Please ask for: Nicola Moore
Email: nicola.moore@arun.gov.uk
Telephone: Ext 37944
Our Ref: BE/81/20/OUT
Your Ref:
Date: 6th August 2020

Application for Outline Planning Permission

Development: Development of 20 residential dwellings, 2,240 sqm of commercial space (Use Class A1, B1(b) B1(c) and B8), landscaping, access, parking and associated infrastructure
Location: Chalcroft Nursery Chalcraft Lane Bersted PO21 5TS

Site Location Plan - 02

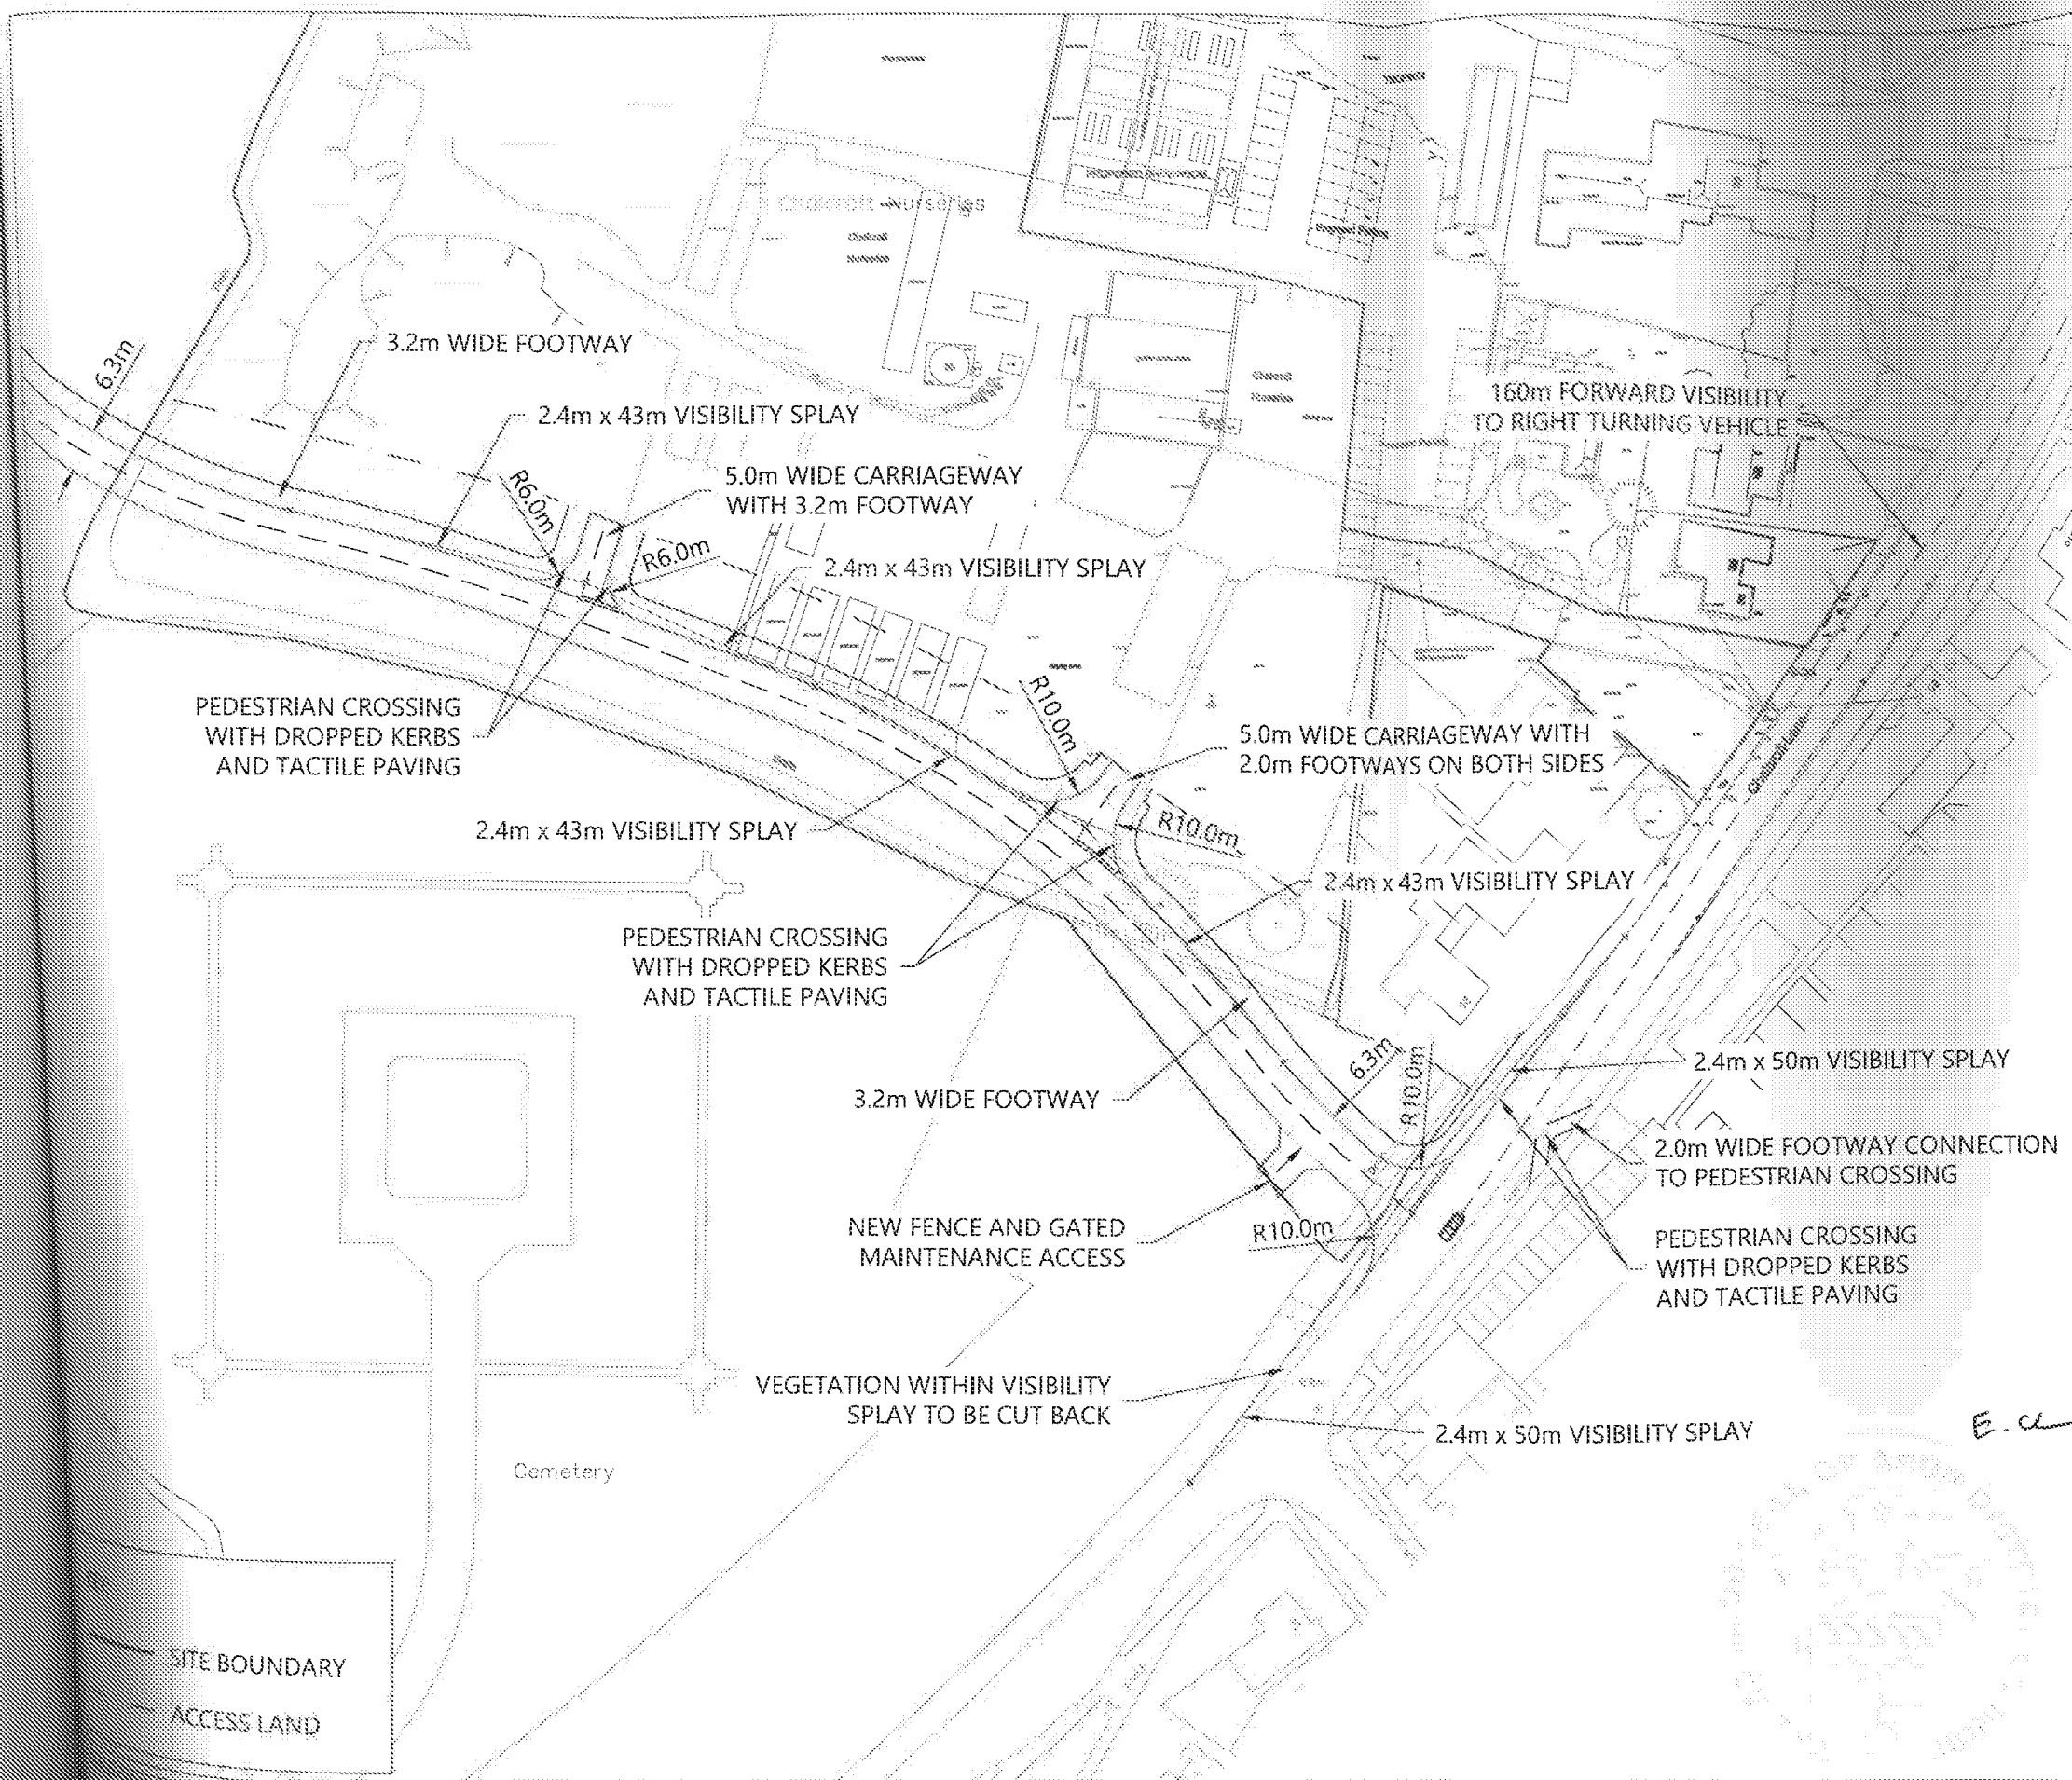
Location Plan

The Location plan should include at least one named road. Please amend accordingly and re submit.

West Sussex County Council require that a visibility splay is provided. A splay is formed for a 30 mph speed limit road by measuring from a point 2.4m back from the kerb edge in the centre of the proposed access. A line should then be drawn from either side of this point for 43 m in each direction to the nearside edge of the carriage way. The splays must intersect land only within the control of the applicant, or within the publicly maintained highway.

The distance will increase with the speed limit of the road. If the road is 40 mph speed limit then the distance should be 120 m either side. For speeds above this please contact West Sussex County Council Highways for advice on what would be acceptable.
